**From:** Hill, Grace <Grace.Hill@e-lindsey.gov.uk>  
**Sent:** 12 December 2025 18:20  
**To:** Hill, Jess <Jess.Hill@sholland.gov.uk>  
**Cc:** De-Ruyck, Chris (ELDC) <Chris.De-Ruyck@e-lindsey.gov.uk>  
**Subject:** H19-1174-25 ecology comments

H19-1174-25 - Land North of 291 Broadgate Road Sutton St Edmund Spalding Lincolnshire PE12 0LR  
Proposed Pair of Semi Detached Houses.

Location of bat/bird bricks 1:250

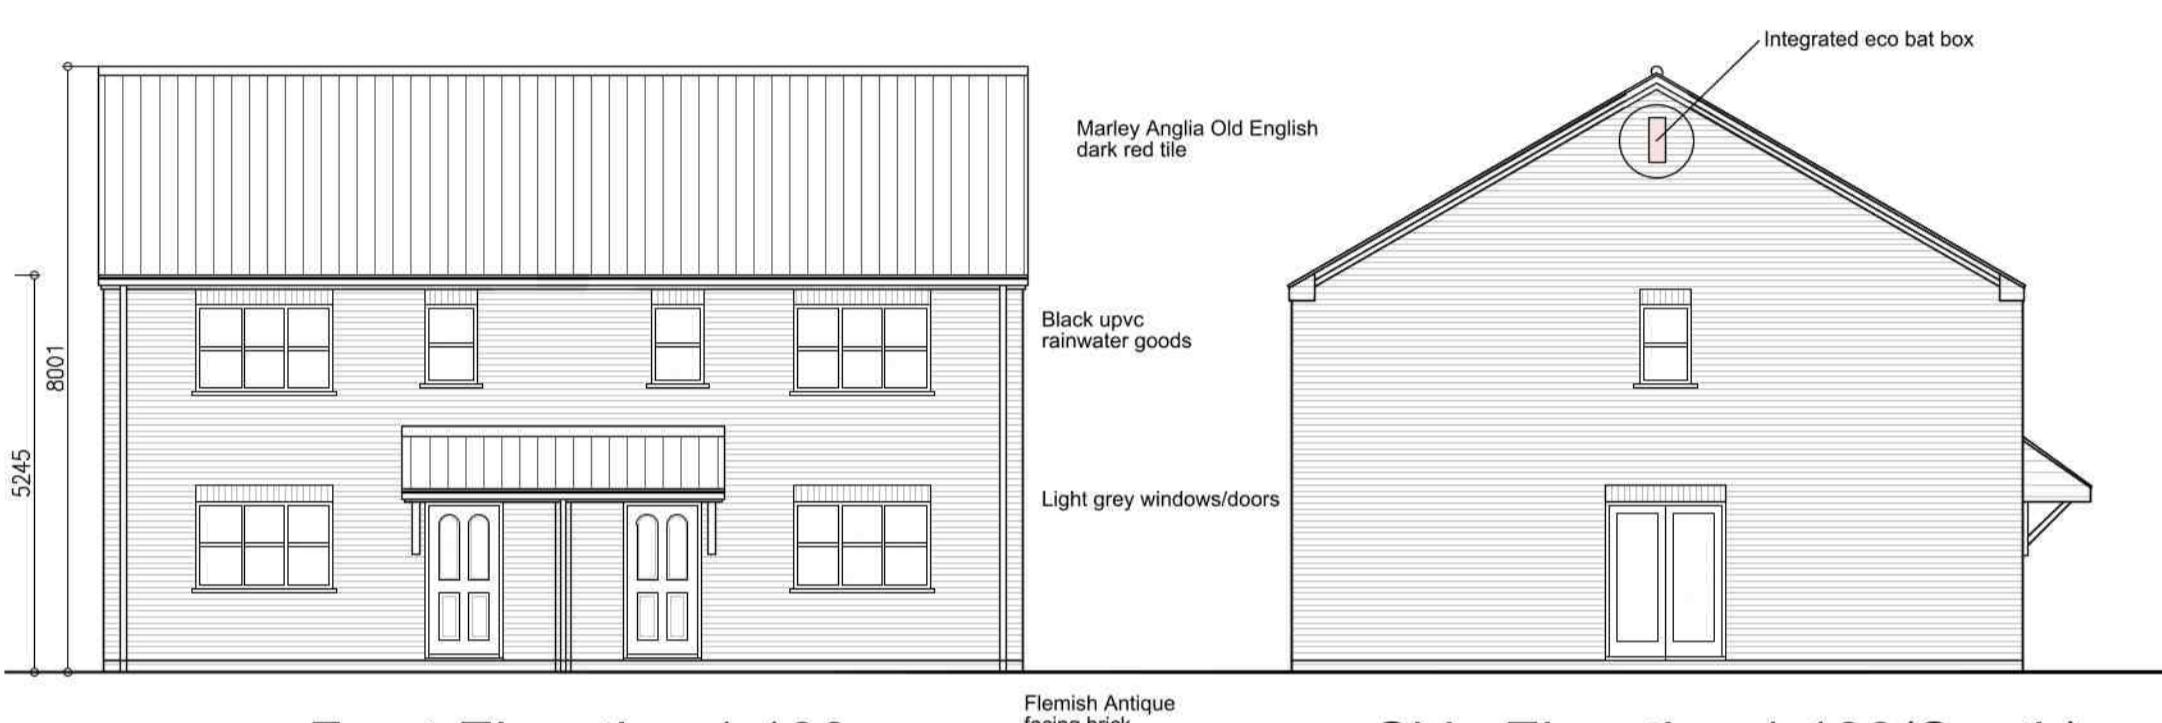
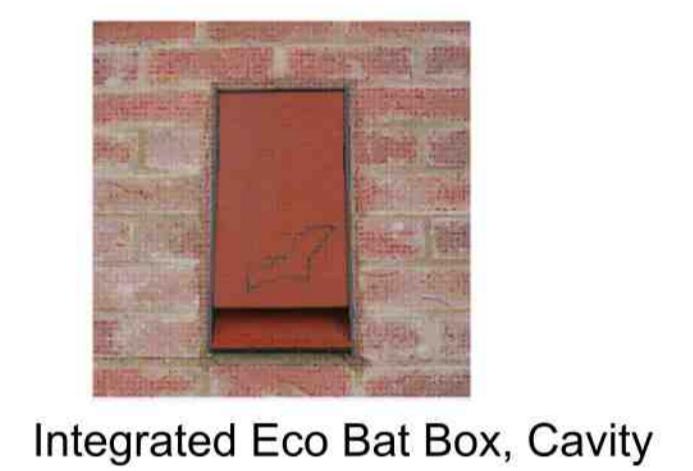
- We request that least 2 integrated universal nest bricks are incorporated into the external fabric of the buildings. These should be located at a height of 4+ m metres, on the north or east elevations to avoid overheating, and grouped colonially where possible, in accordance with best-practice guidance such as British Standard BS 42021:2022. The bricks must be installed during the construction phase and retained thereafter for the lifetime of the development.

- We also request that one integrated bat box (e.g., Integrated / Built-In Bat Boxes, Integrated Eco Bat Box | The Nestbox Company) is added to the development. These are required to enhance biodiversity and meet Local Plan Policy 7.2.14.

- In both cases, the authority requires the applicant to submit sufficiently detailed maps that indicate the proposed location of bird/bat boxes on-site.
